A57 Link Roads

8.3 STATEMENT OF COMMON GROUND WITH HIGH PEAK BOROUGH COUNCIL

Regulation Number:	Regulation 5(2)(c)
Planning Inspectorate Scheme Reference	TR010034
Application Document Reference	TR010034/APP/8.3
Author:	A57 Link Roads Project Team, National Highways and Atkins

**6.4 Environmental Statement  
Figure 5.4 Air Quality EU Compliance Risk  
Assessment**

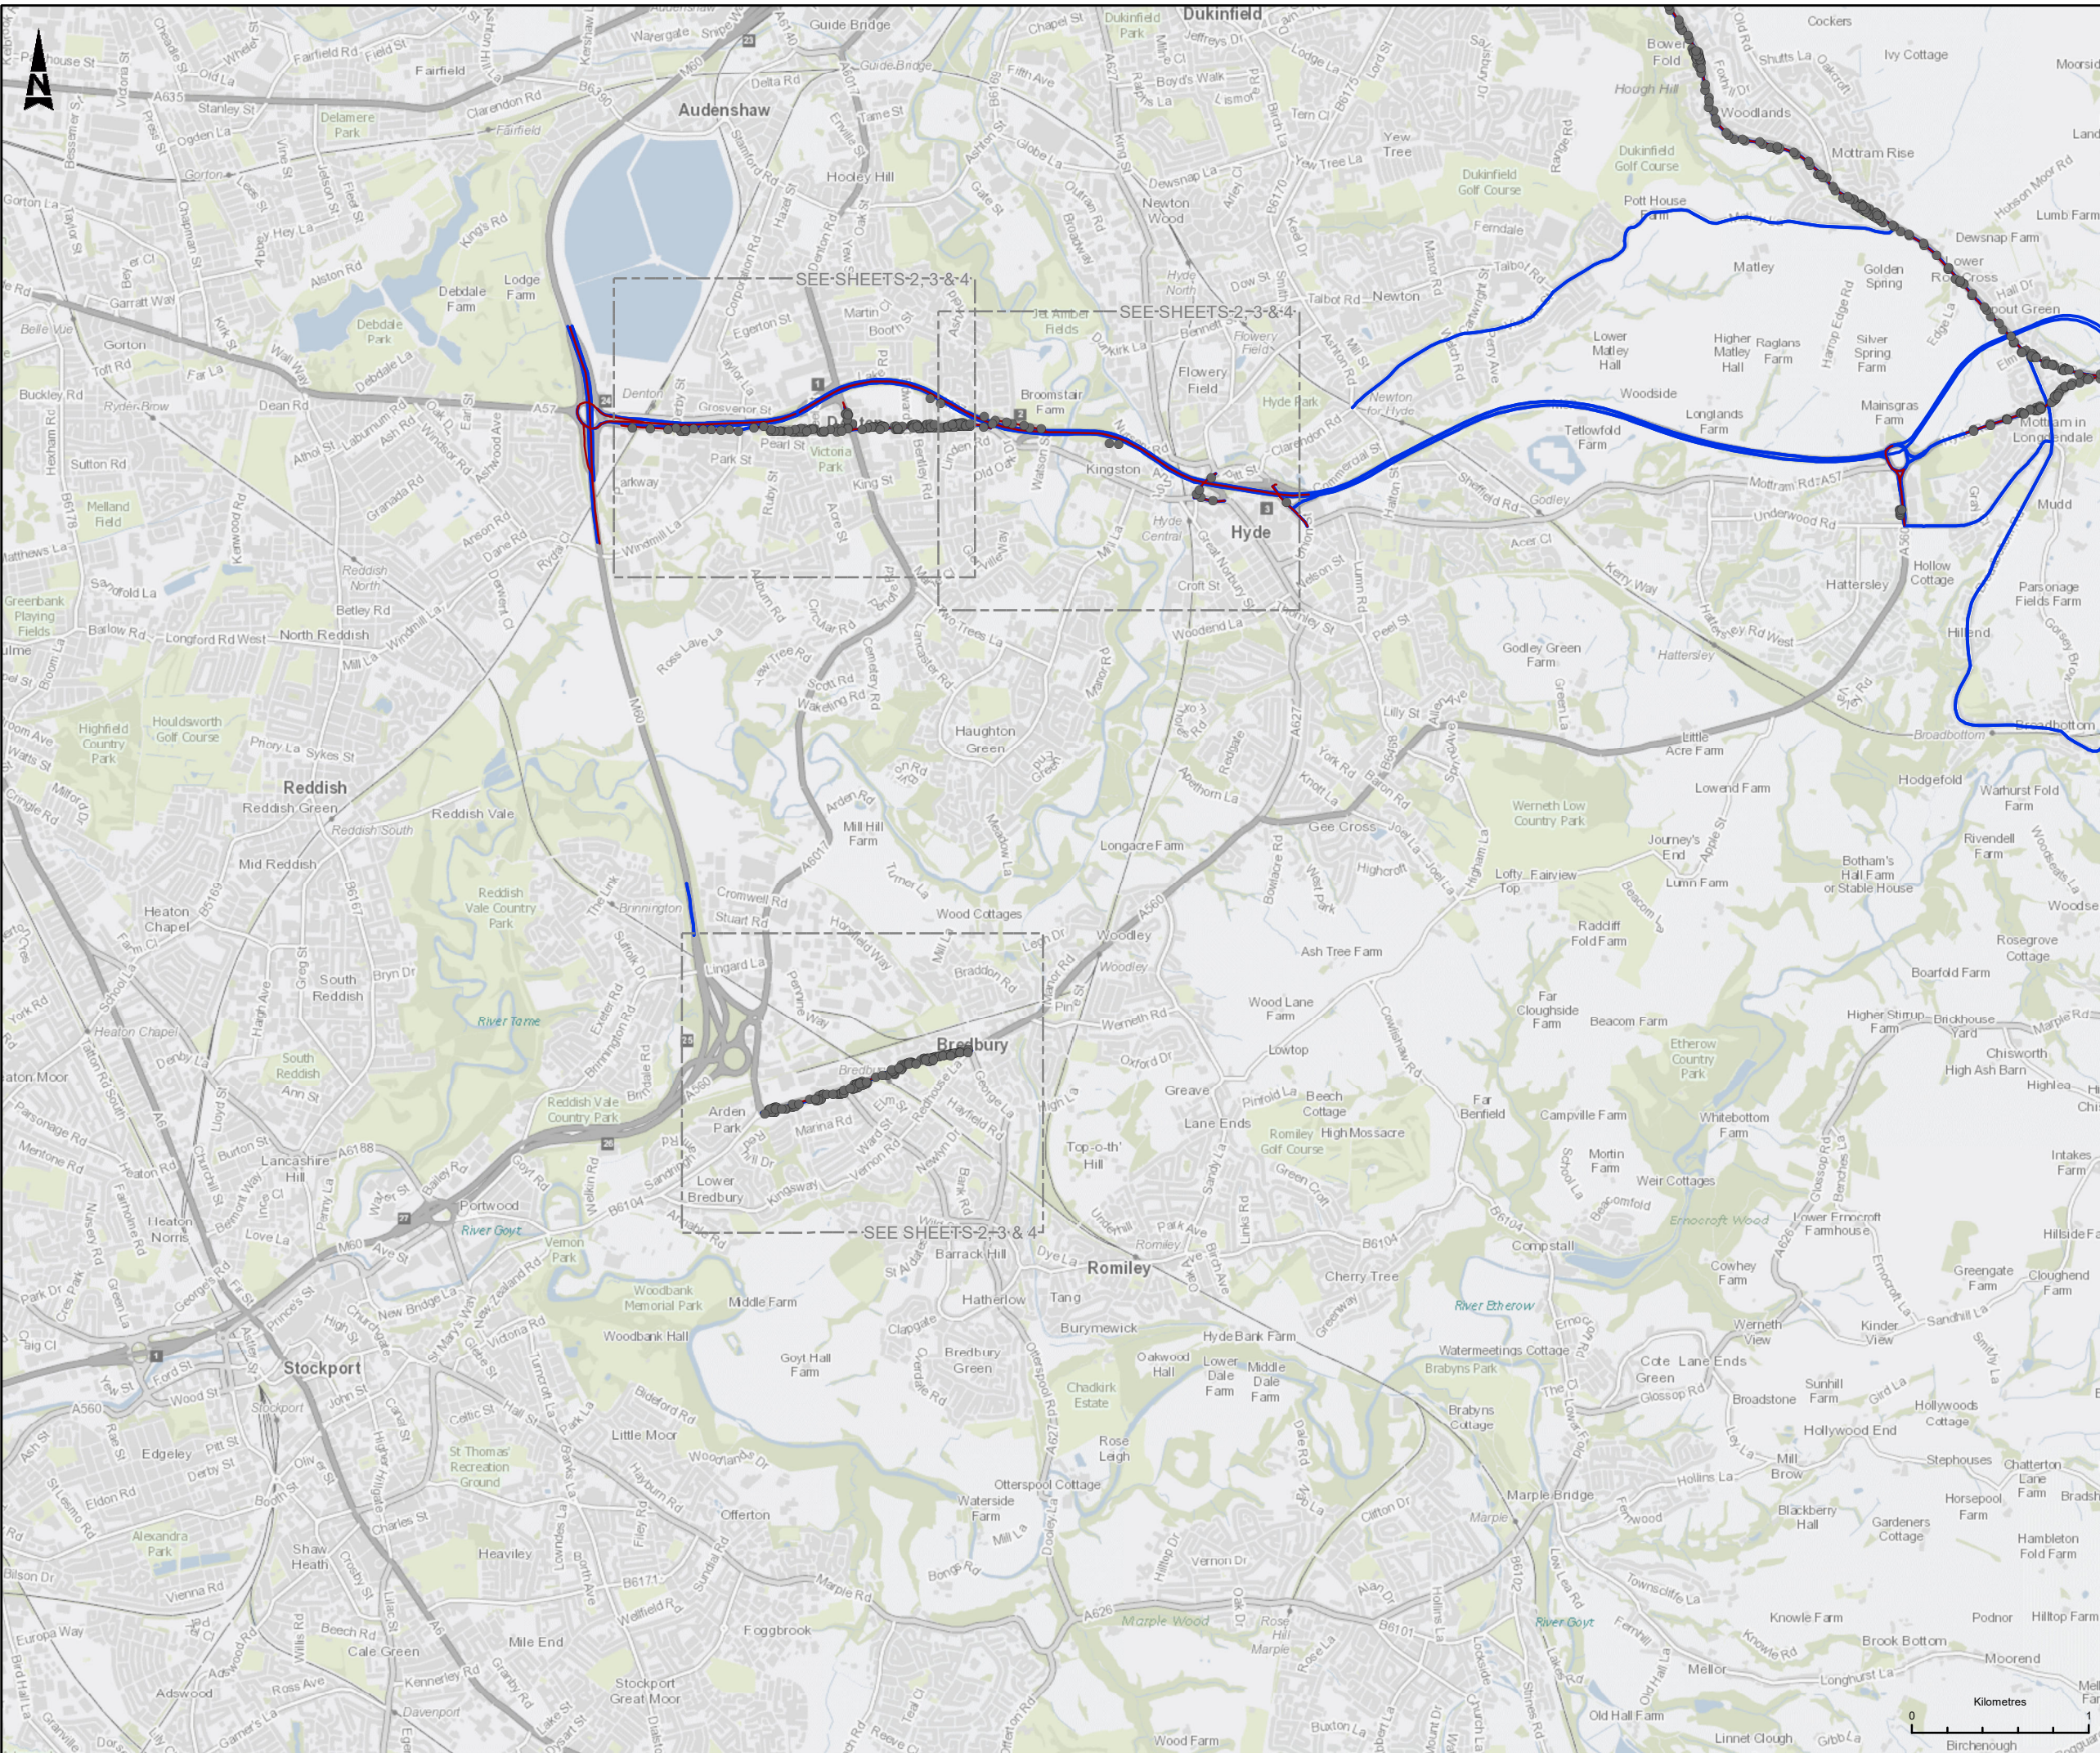
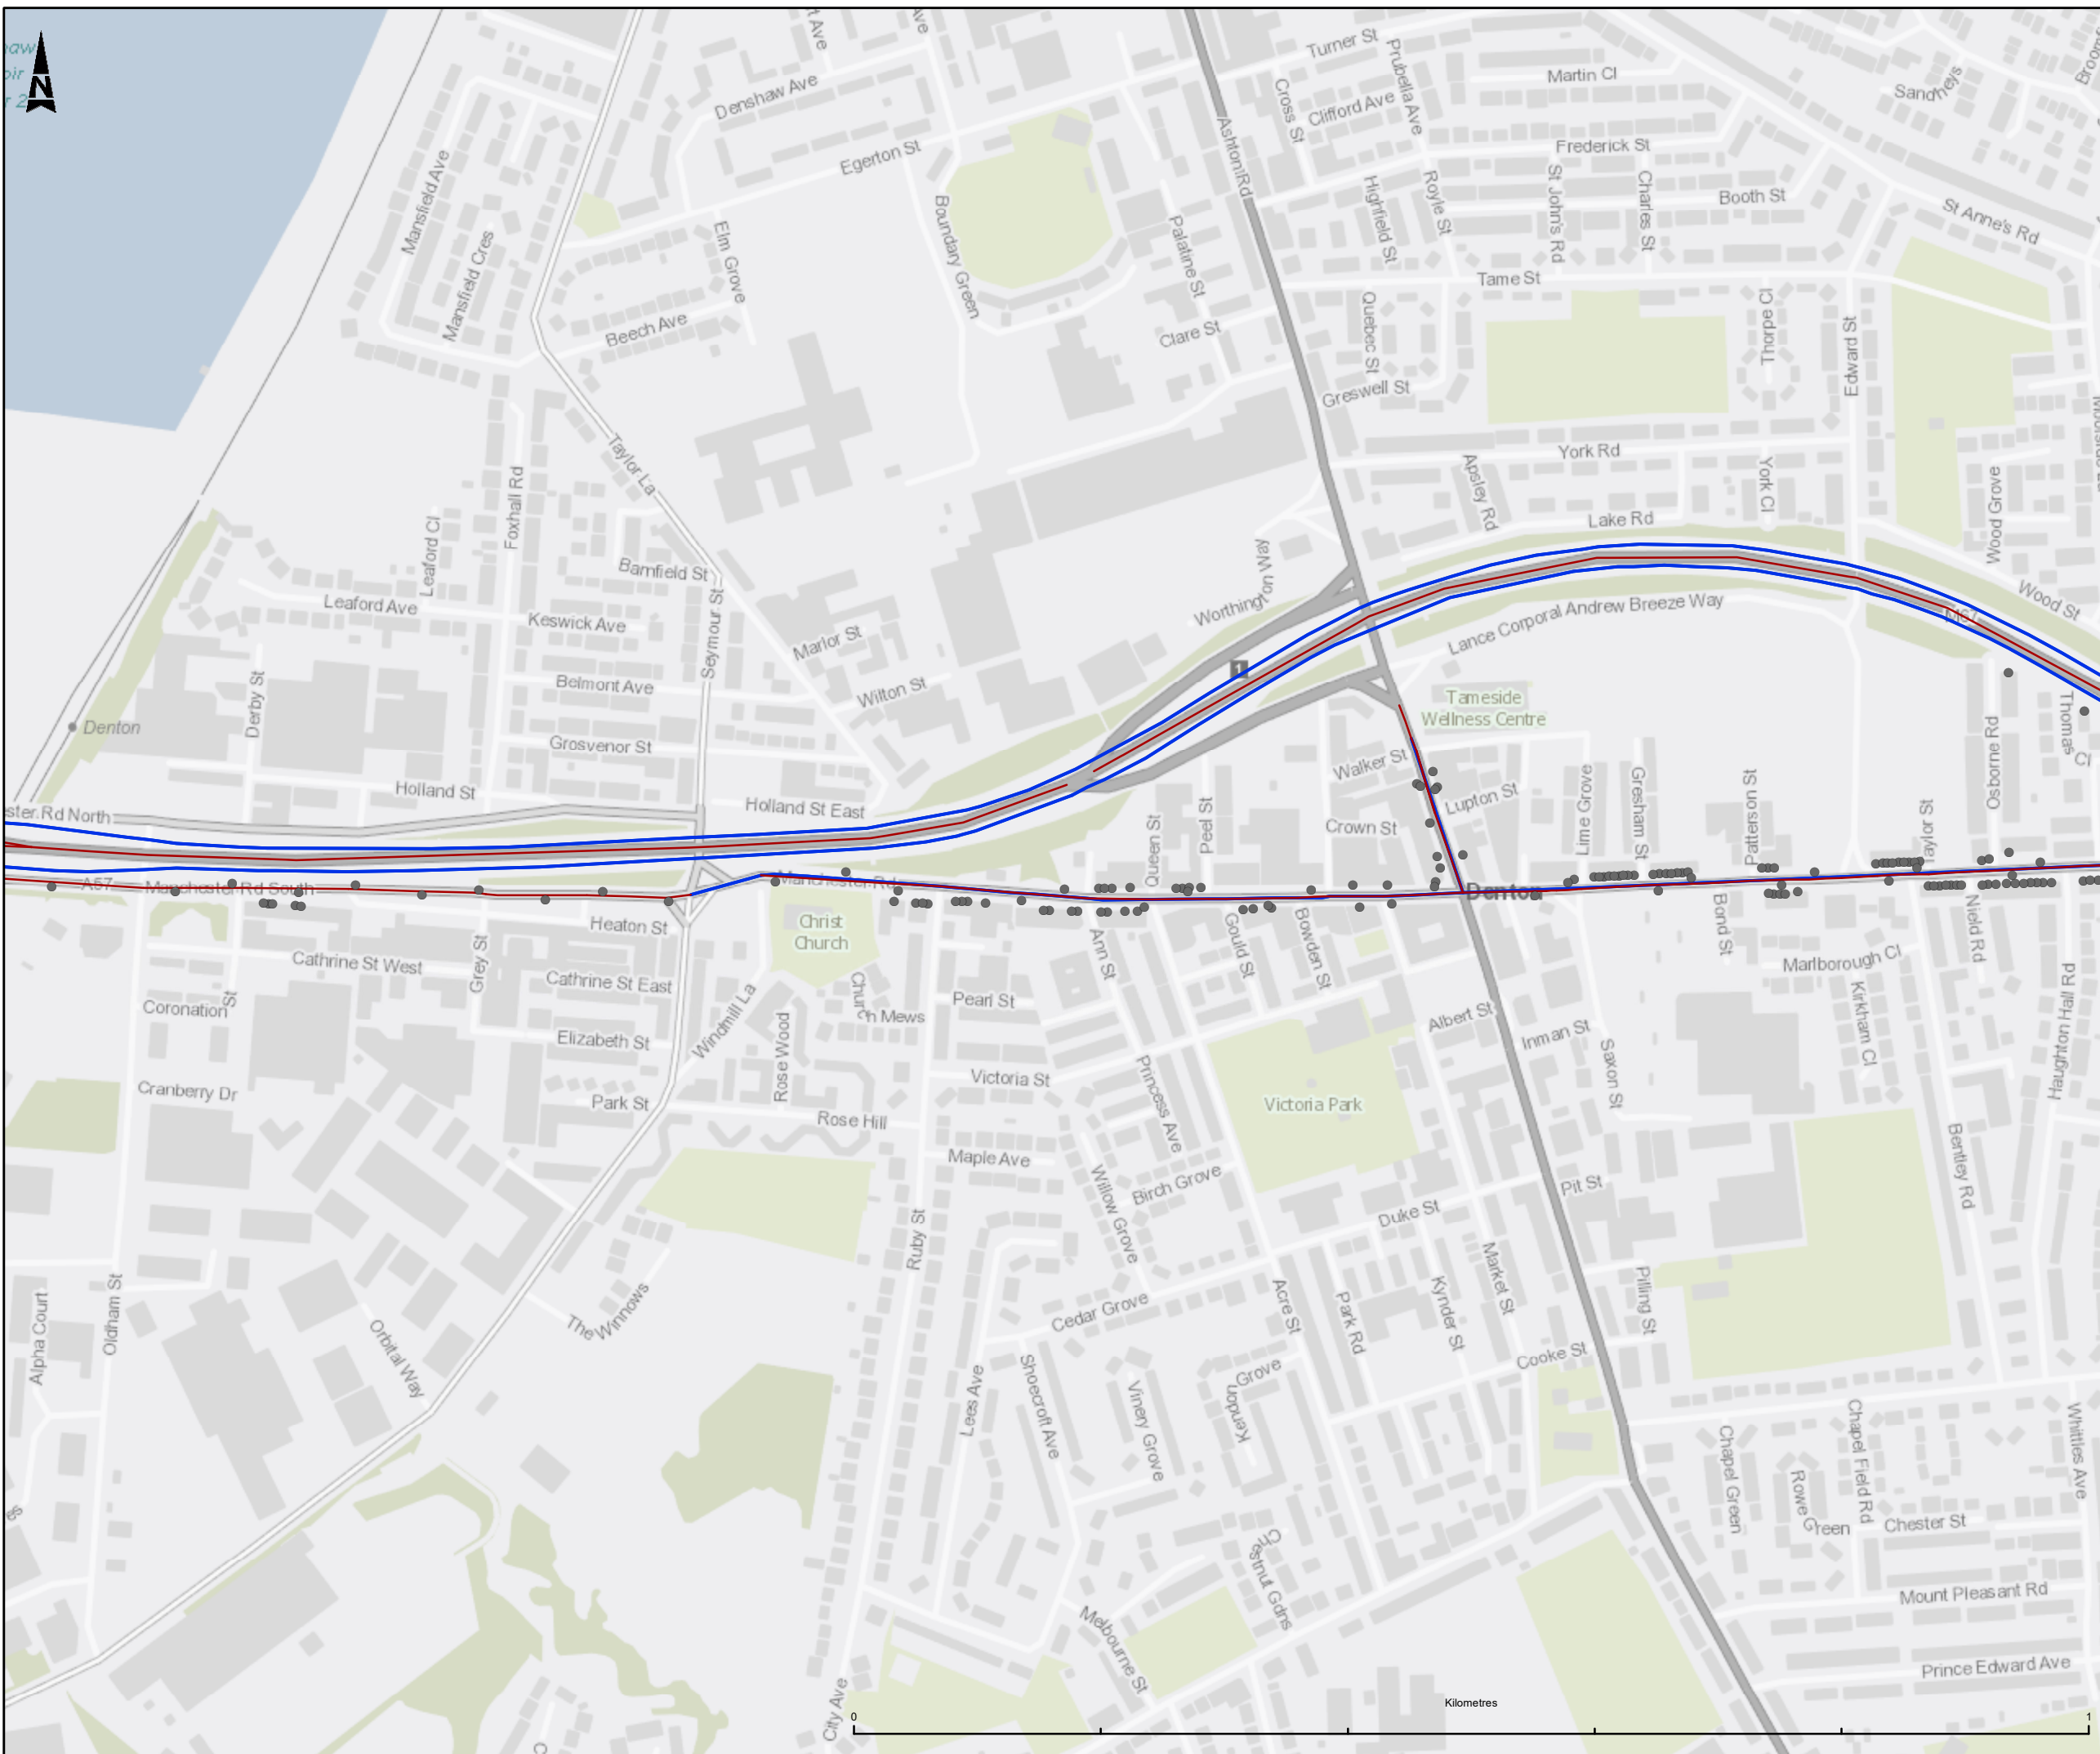
3.2	Environmental Statement (ES) [APP-061]	Air Quality Methodology Dinting Vale	The Consultee questioned the air quality results at Dinting Vale.	The air quality assessment has been undertaken in accordance with DMRB LA105 with the air quality study area determined on the basis of traffic change criteria given this guidance. A detailed assessment of air quality has been undertaken for all areas where traffic changes are expected, which includes the Dinting Vale area. Full results will be reported in the Environmental Statement [APP-061].	Agreed
